# FINAL DRAINAGE REPORT

## MEADOWBROOK TOWNHOMES DIRT BORROW SITE EL PASO COUNTY, COLORADO

OCTOBER 2018

Project #43-089  
PCD Project No.CDR-18-009

GRADING & EROSION CONTROL PLAN

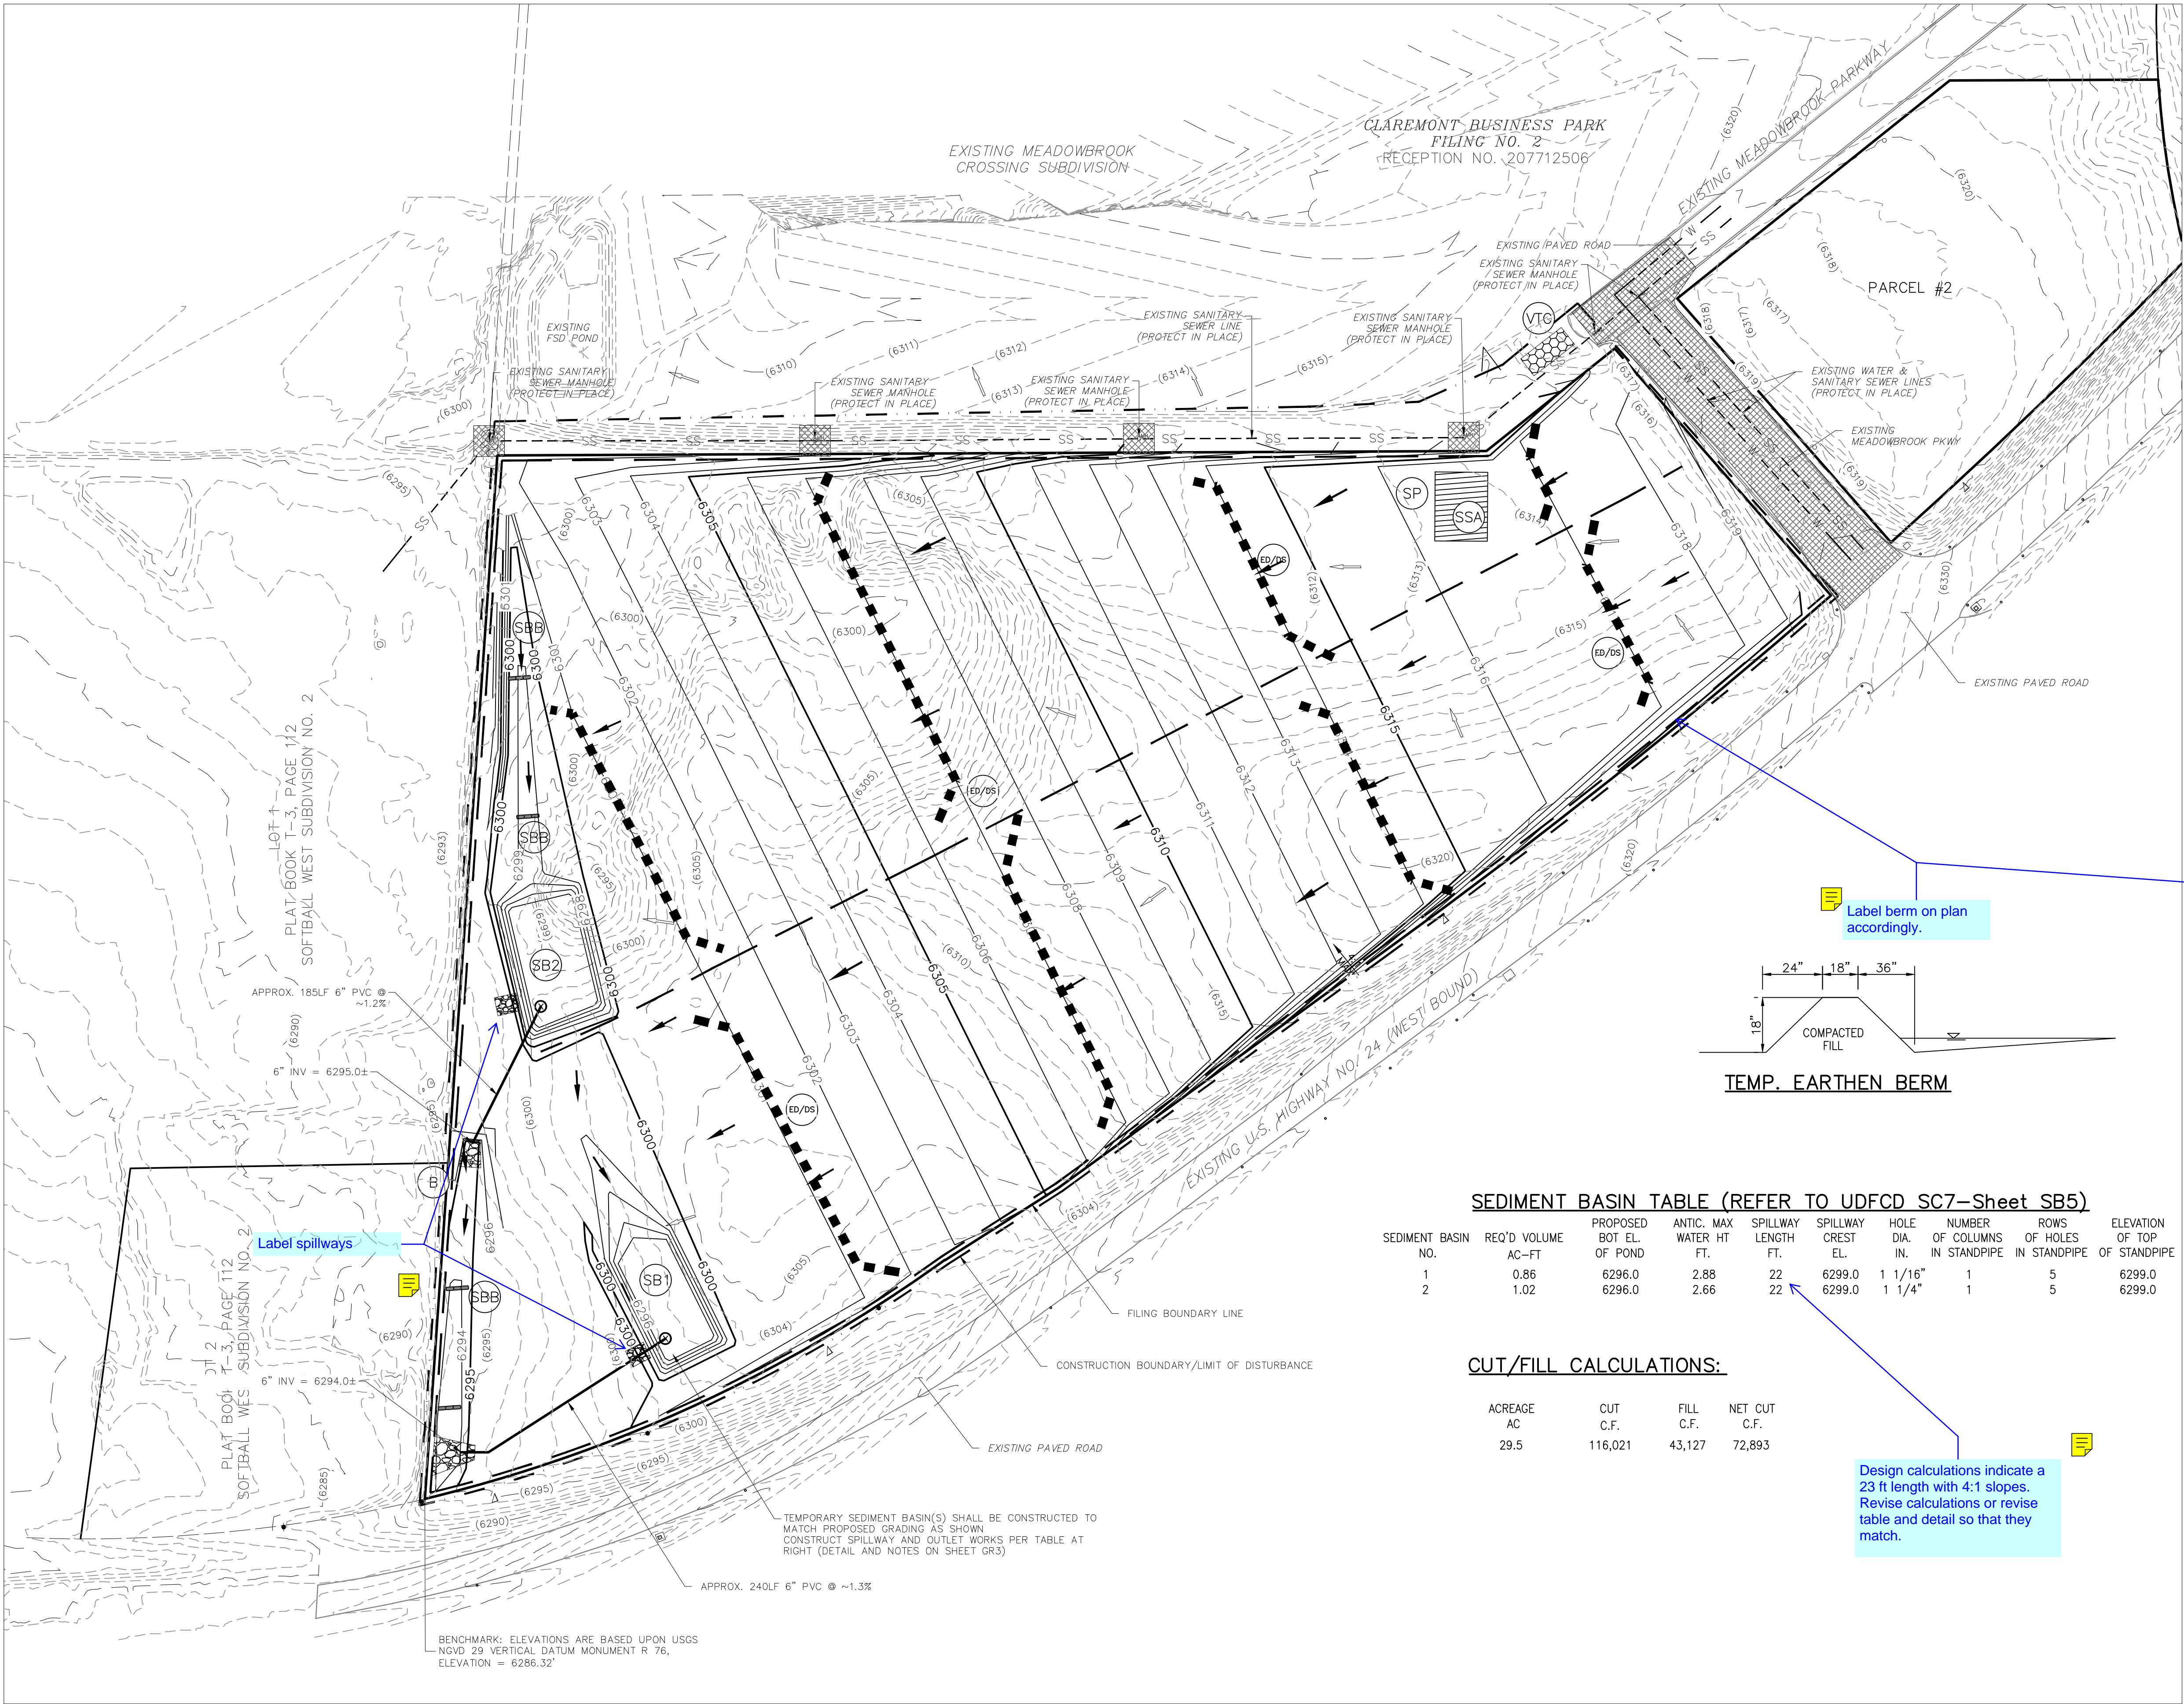
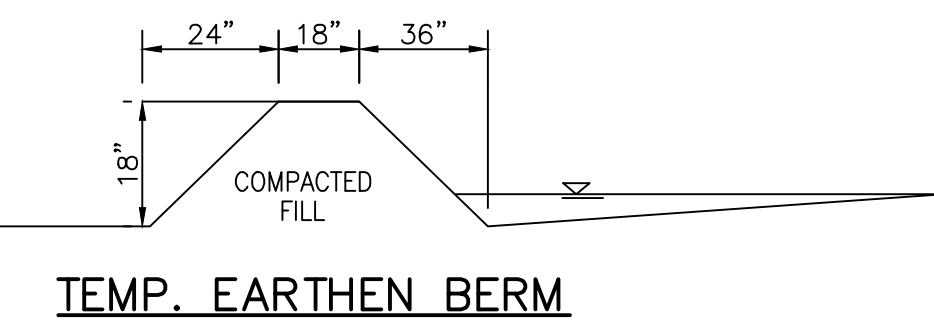
SB1 calculations and table on GEC indicates 22 ft. Revise.

SB2 calculations and table on GEC indicates 23 ft. Revise.
